5 February 2018

### **Mount Pleasant Coal Mine Modification 4 (DA 92/97 MOD 4) – Modification Proposal**

**Prof David Durrheim**  
**Service Director – Health Protection**  
**Hunter New England Population Health**

MACHEnergy
MOUNT PLEASANT OPERATION
General Arrangement of the
Key Modification Elements

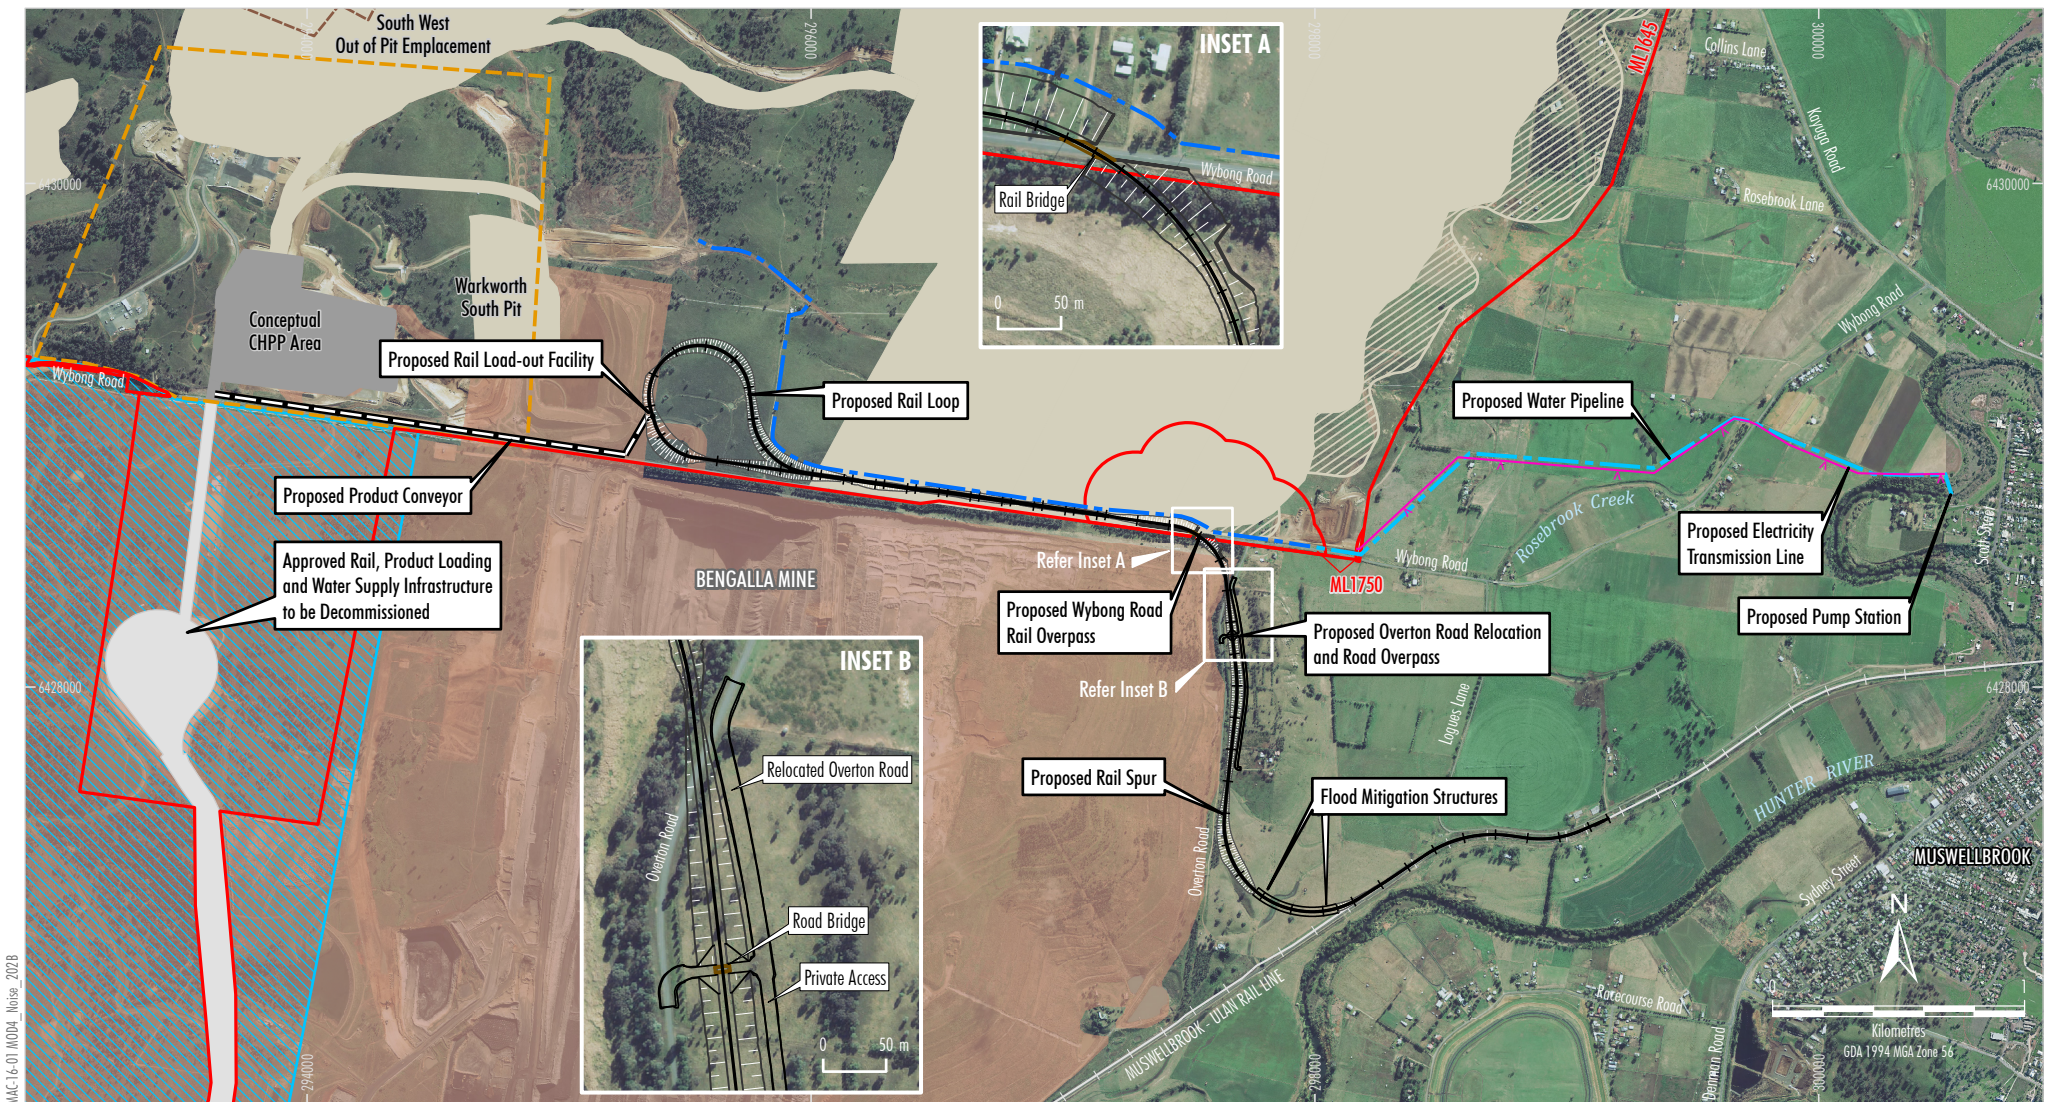
The Modification includes the relocation of the Hunter River water supply pump station and water pipeline. The new location is approximately 1km downstream of the Muswellbrook town water supply pumping station.

It is unclear from the EA whether the discharge point for the surplus water from the mine is the same location as the offtake point from the Hunter River, or another location. It is also unclear whether there are separate offtake and discharge pipes, or if just one pipe is used for both purposes.

We have concerns about the quality of discharged water, specifically what potential contaminants it may contain, and whether there is potential for this water to impact on the Muswellbrook town supply. If only one pipe exists, then this may also be an issue for the onsite potable water supply.

We request that the proponent address these issues further for clarification.
